**WELWYN HATFIELD COUNCIL**  
**PLANNING CONTROL COMMITTEE**  
**19<sup>TH</sup> NOVEMBER 2003**  
**REPORT OF THE CHIEF PLANNING &**  
**ENVIRONMENTAL HEALTH OFFICER**

**S6/03/380/FP**  
**CONVERSION OF EXISTING ACCOMMODATION BLOCK AND**  
**HANGER, TO TWENTY FOUR RESIDENTIAL UNITS AND CAR PARKING**  
**ASTWICK MANOR, COOPERS GREEN LANE, HATFIELD**

Scale	Date	Drawn	No.	Rev.
1:100	FEB 2003	ID	4274/59

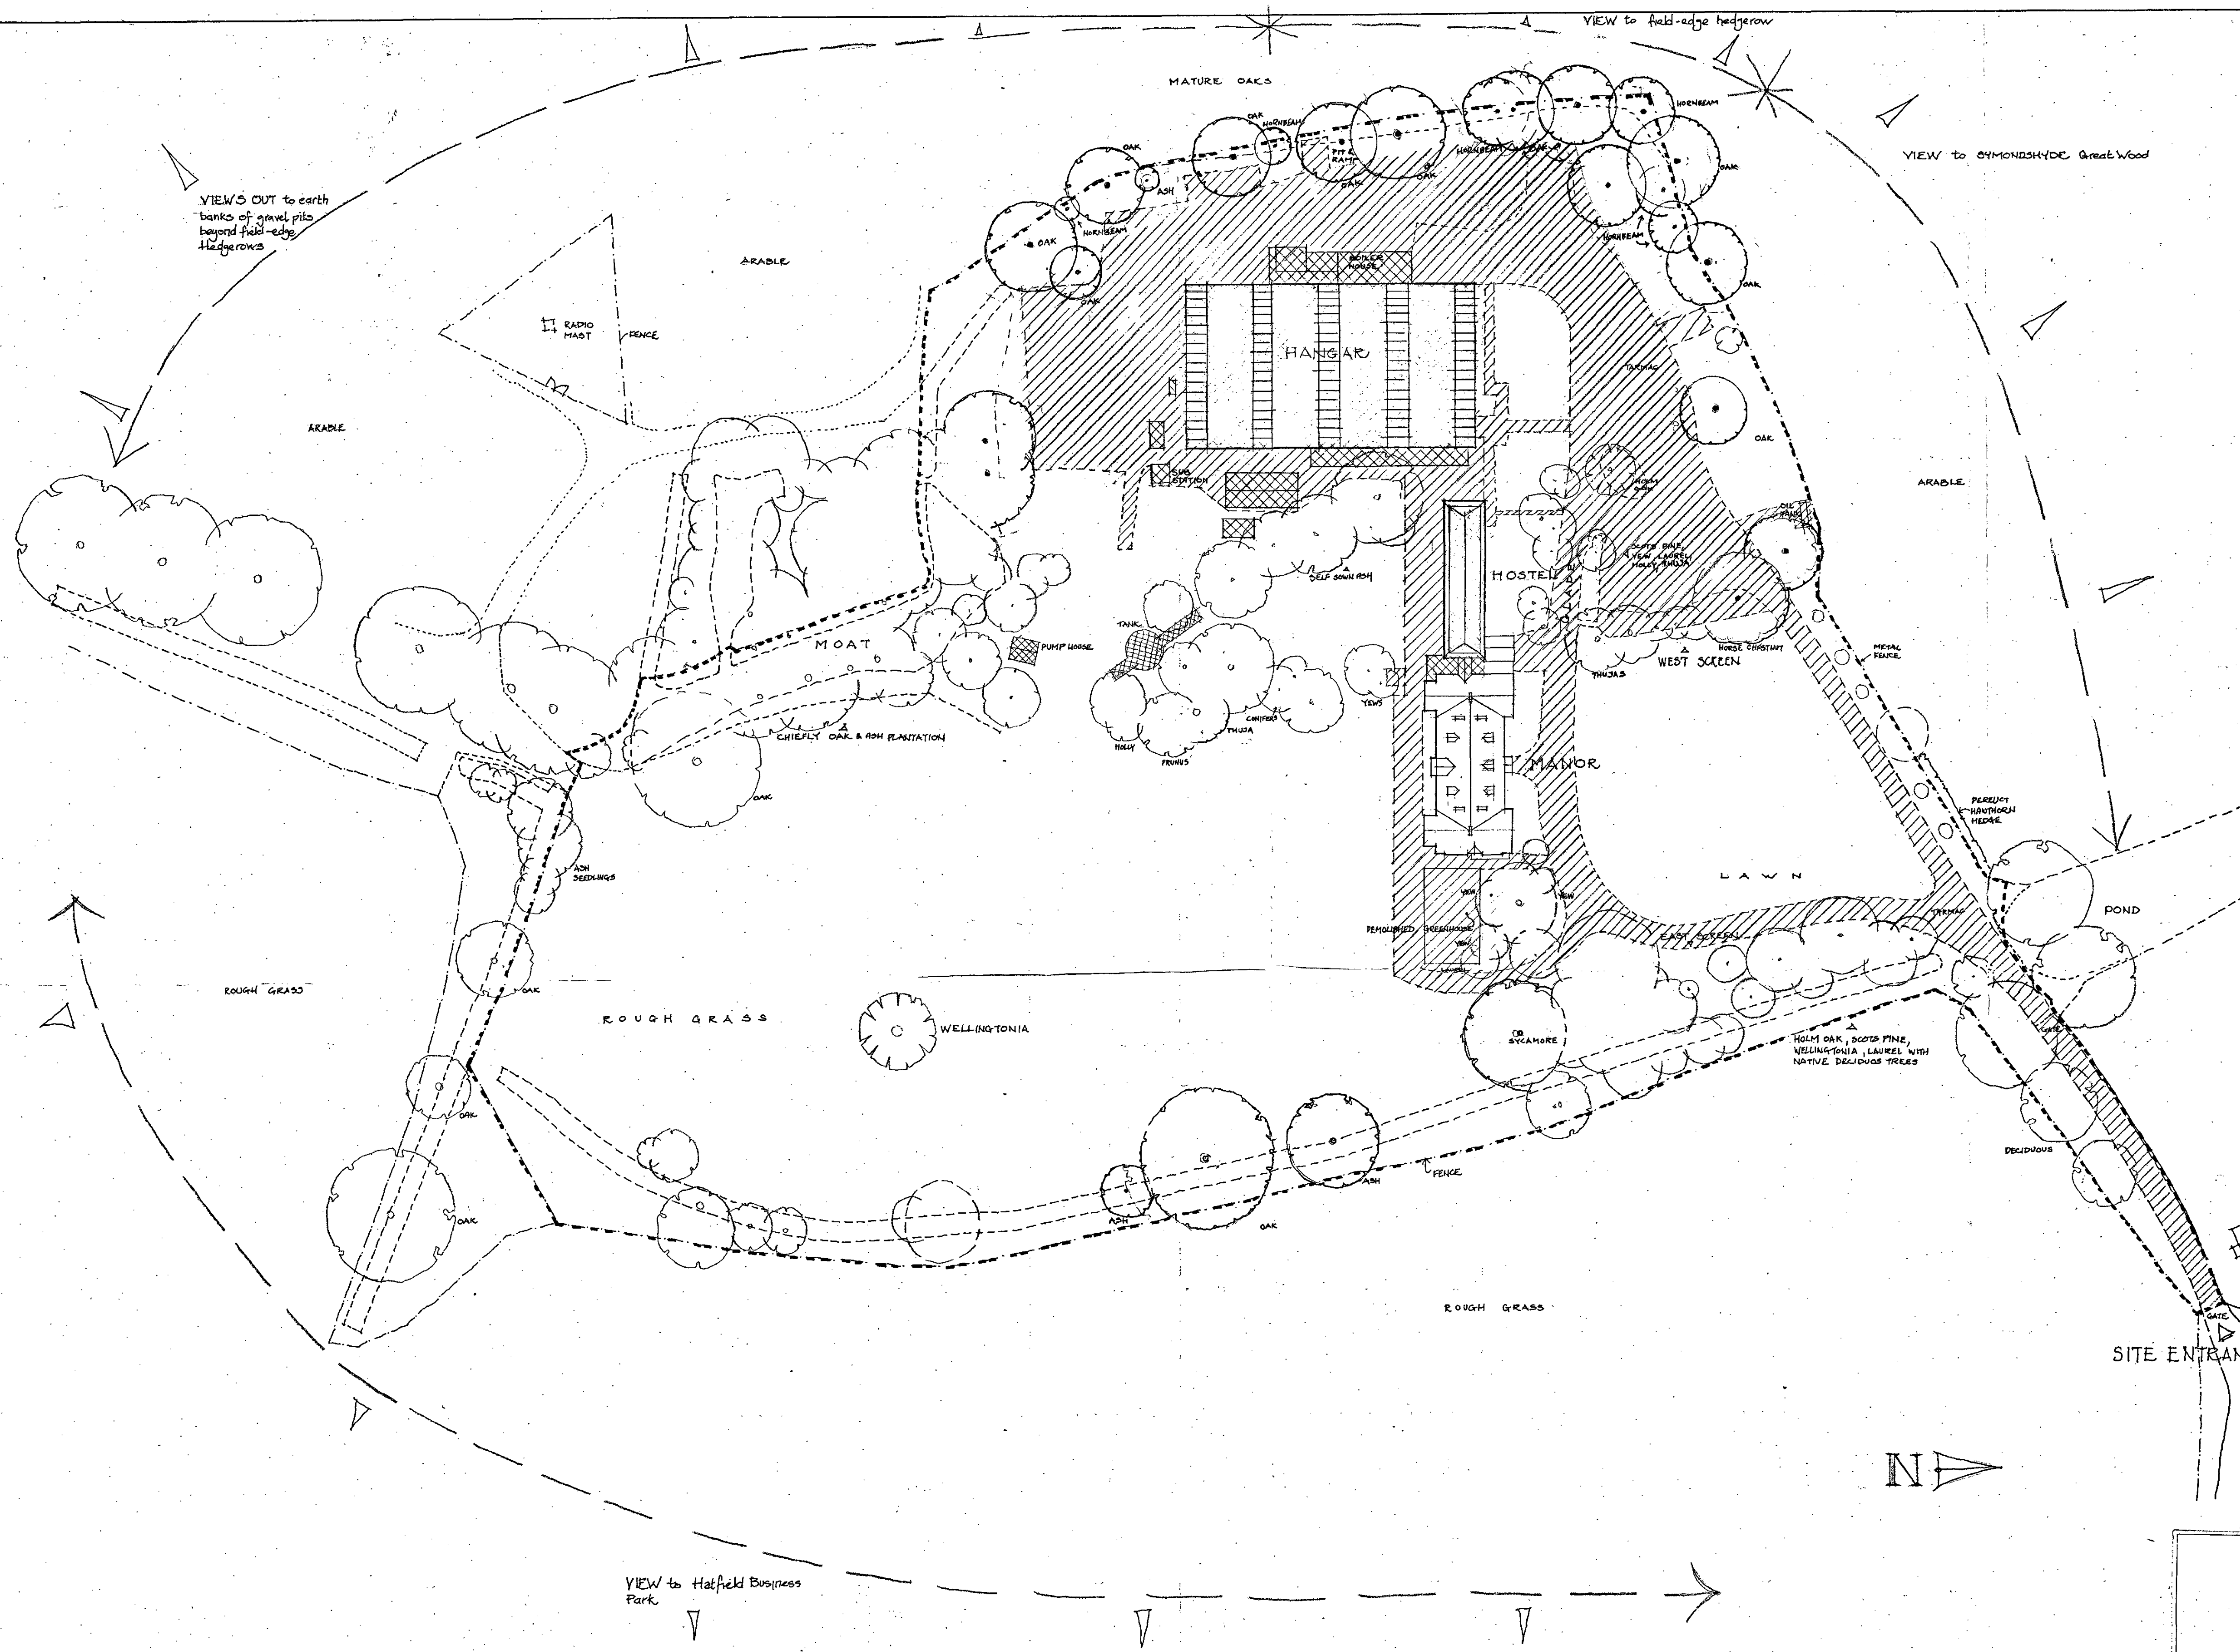
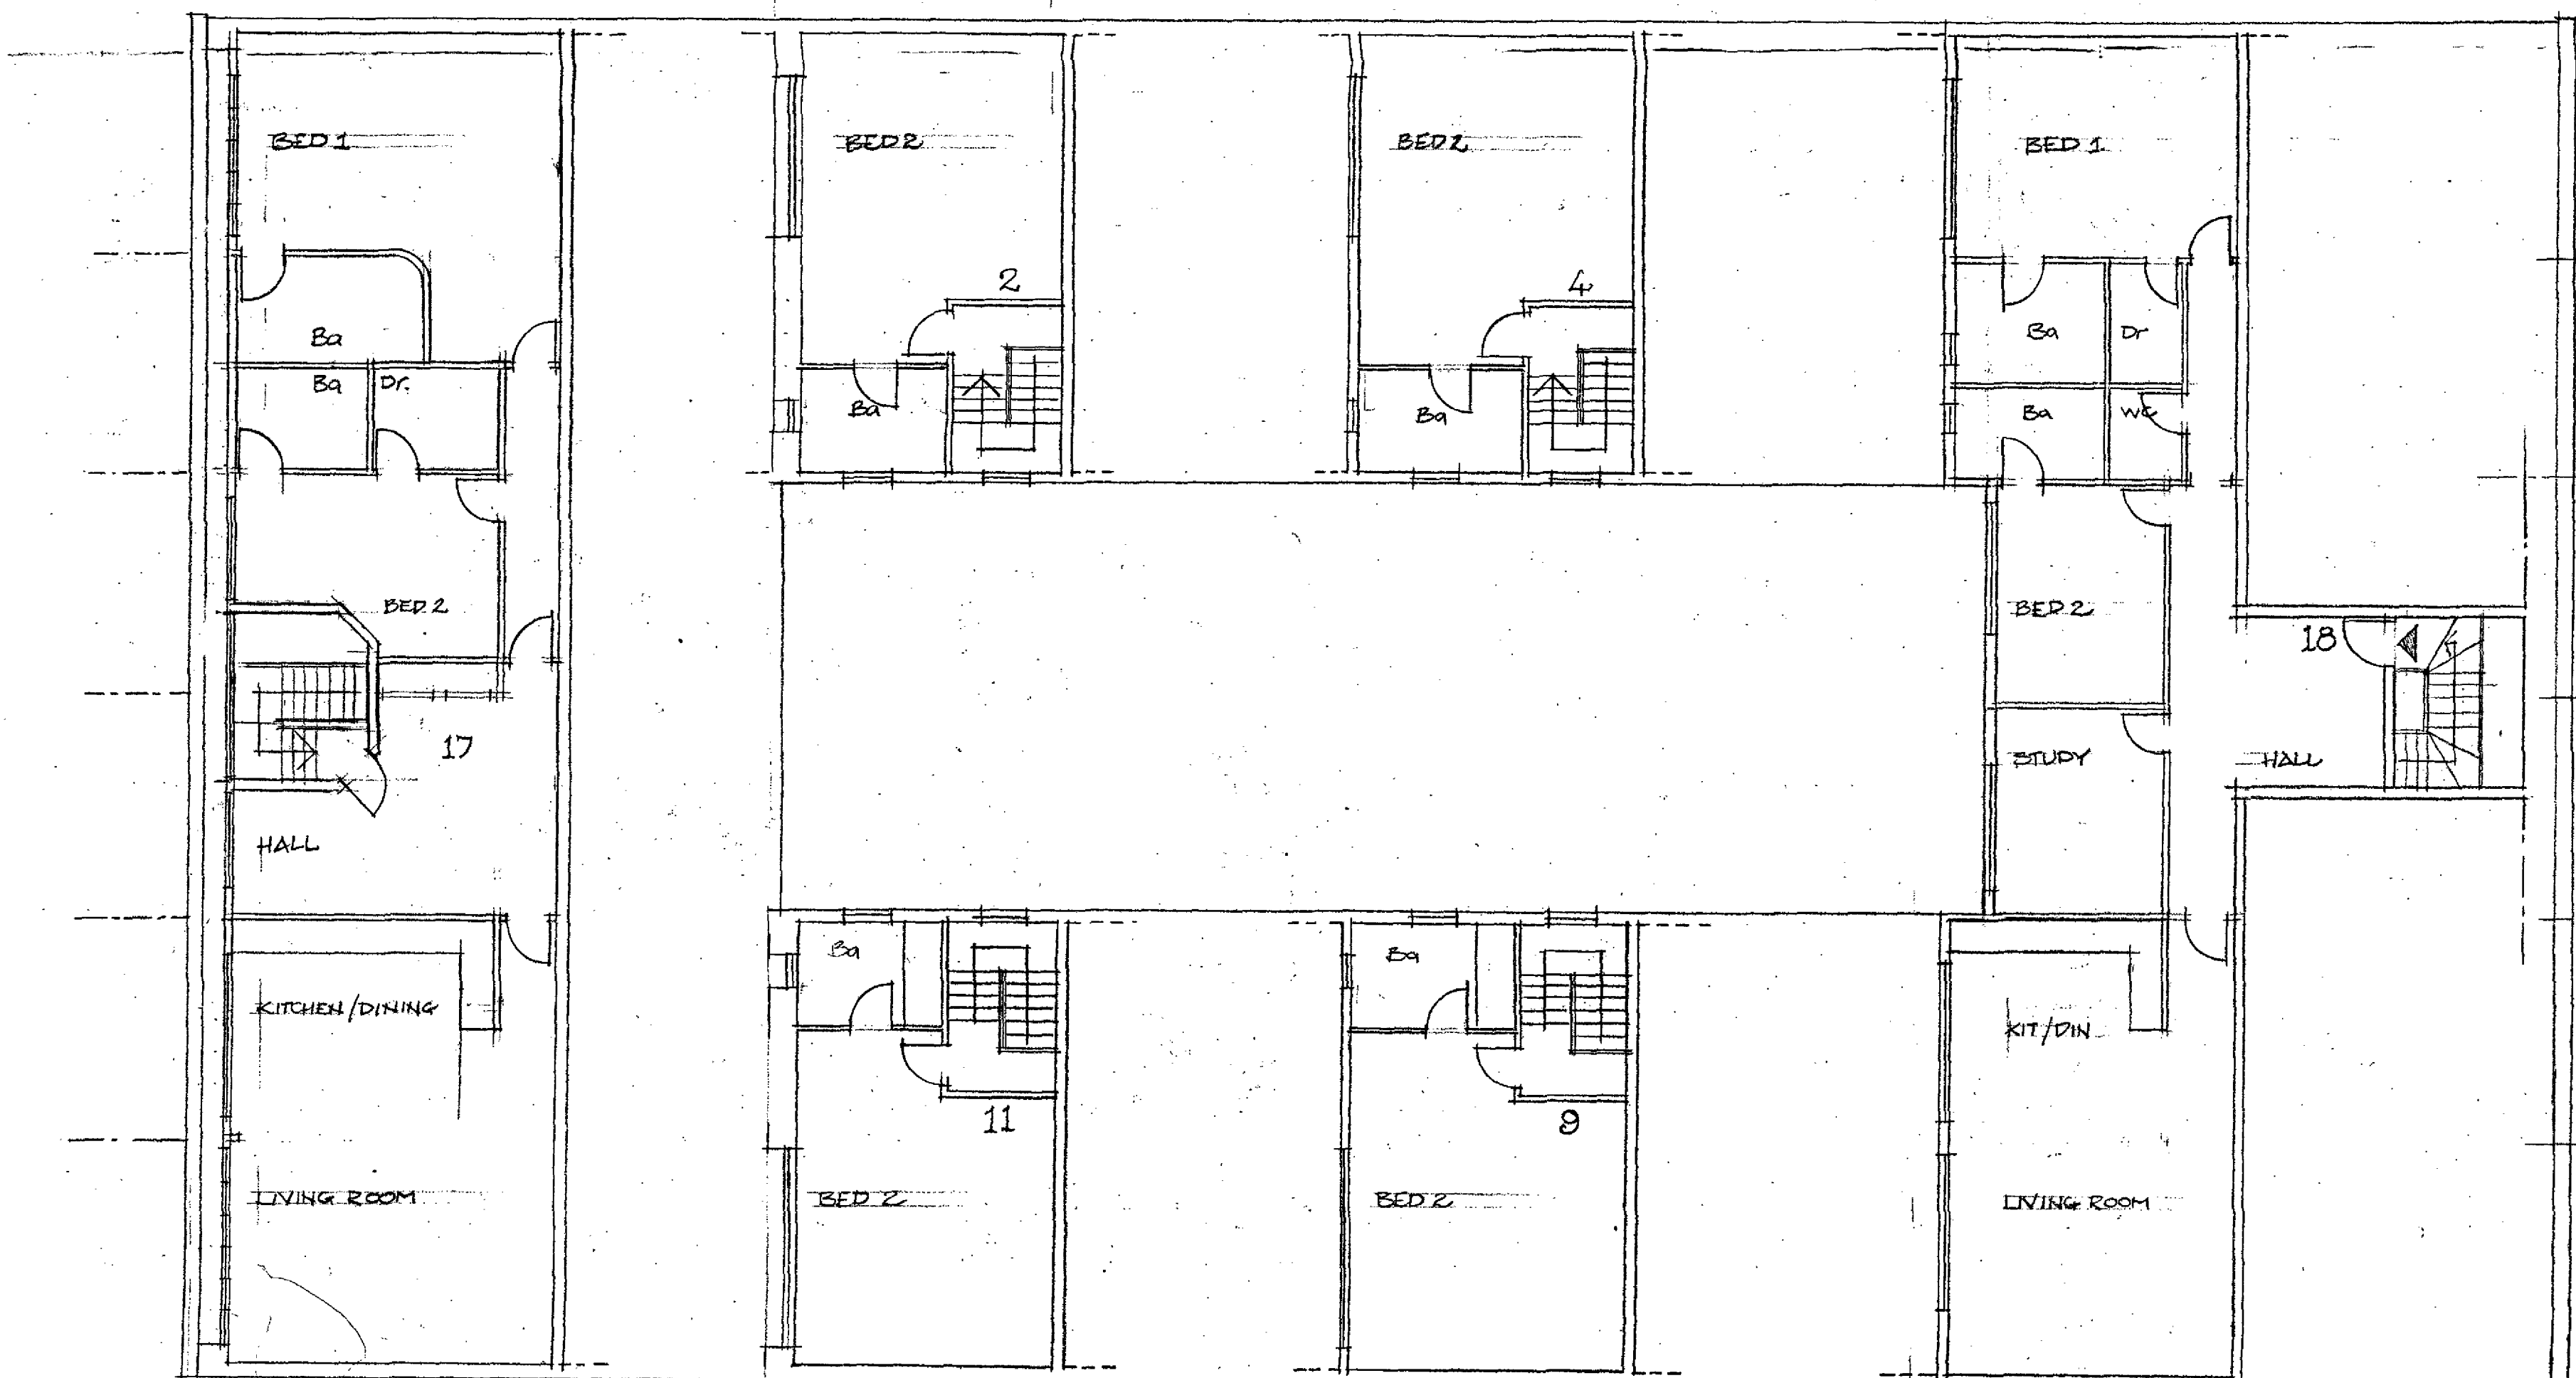
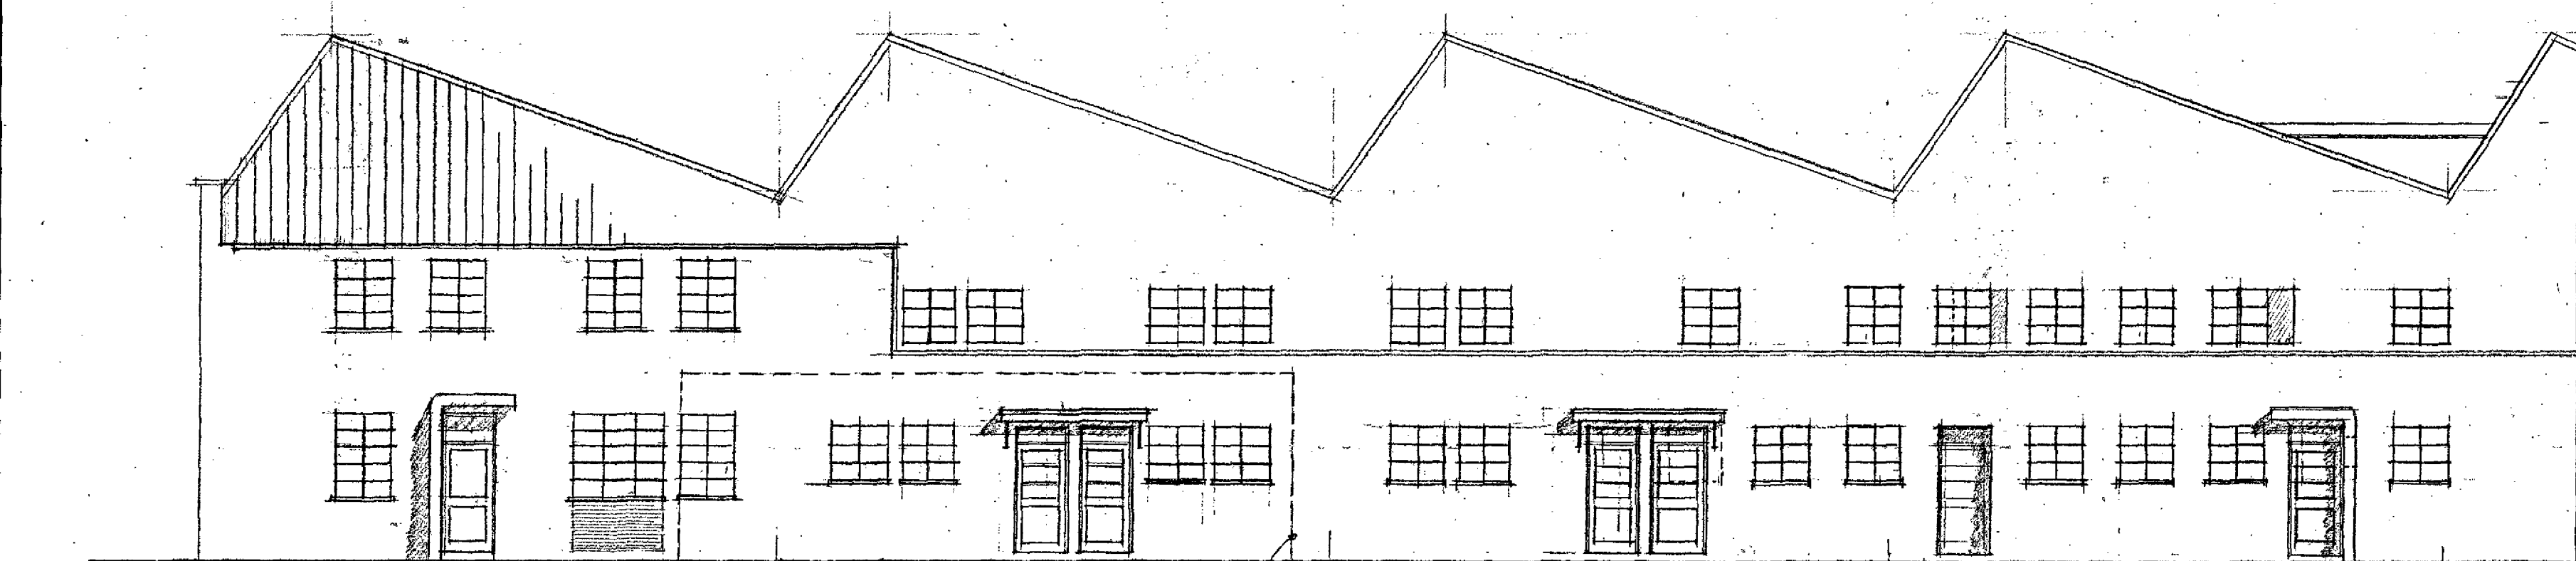
8.3 Prior to the commencement of the development there shall be submitted to and agreed in writing by the LPA details of the sound and thermal insulation to be provided in the converted hanger building.
